Re: ACP-324165-26

Maughanaclea Wind Farm / Enerco's Application
to Construct 14 Industrial Wind Turbines on Maughanaclea
a 110kV substation and 110kV underground cabling connection & associated works

#### 12.5.1.4 NML4

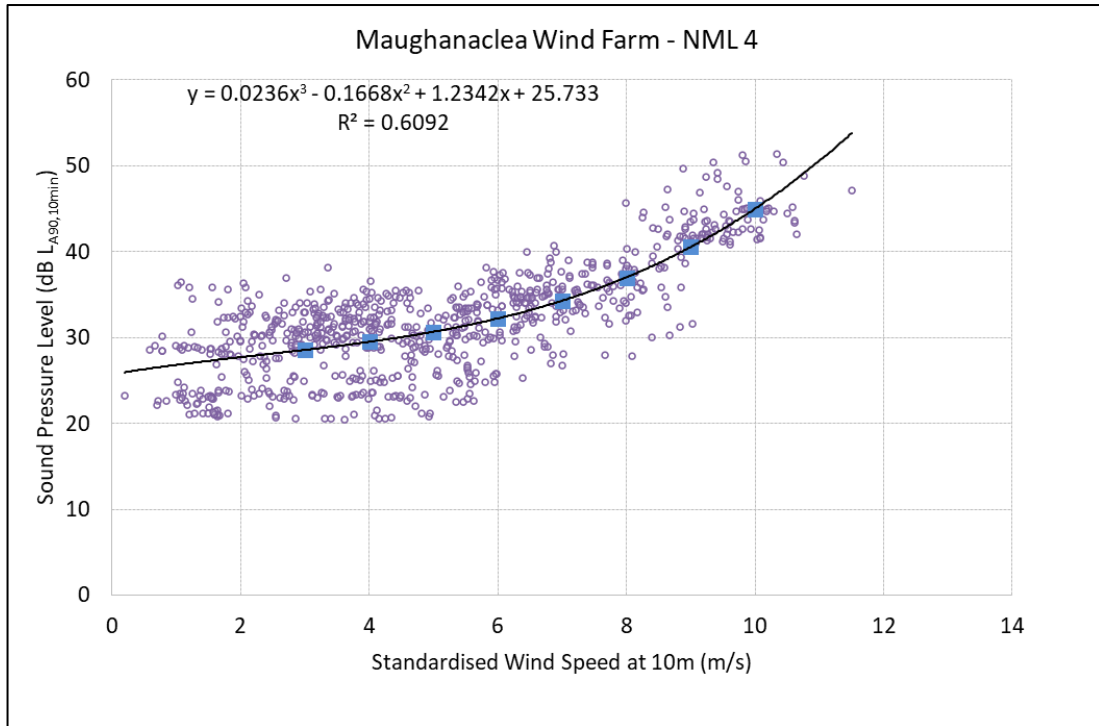
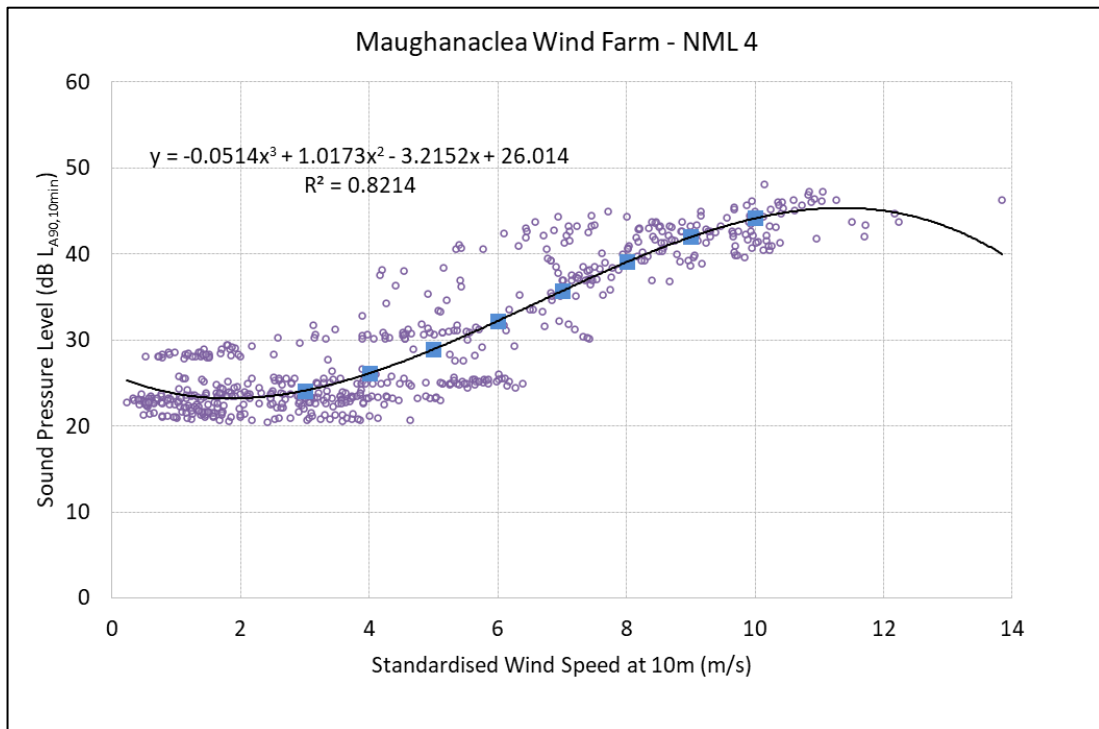
My primary concern relates to the baseline noise measurements upon which the assessment is based. The only noise monitoring location situated within the Mealagh Valley itself was NML4. The description provided within the application refers to a rural environment characterised by birdsong, wind in vegetation and infrequent traffic. However, this description does not reflect the full reality of conditions surrounding the monitoring location.

As illustrated on the next page, NML4 was located in proximity to one of the busiest farming areas in the upper Mealagh Valley, including active agricultural operations, livestock movement and nearby land-management activities. During the monitoring

period, local residents also observed chainsaw activity, rock-breaking and other intermittent noise sources within the wider area. These factors have the potential to elevate background noise levels above those typically experienced by many residents elsewhere in the valley.

I do not suggest that such activities should have been excluded from monitoring. However, I believe they should have been transparently described and considered when presenting baseline conditions to the Commission. Instead the NML4 was described as a "quiet garden location" with "infrequent traffic & birdsong".¹³

Decision-makers are entitled to a complete and accurate understanding of the circumstances under which background noise measurements were obtained. The photos, maps, and descriptions of monitor locations do not paint an accurate picture.

This issue is important because background noise measurements directly influence the operational noise limits subsequently considered acceptable. If baseline conditions are elevated above the area's typical rural sound environment, then the resulting assessment may underestimate the real-world effect of turbine noise on nearby residents.
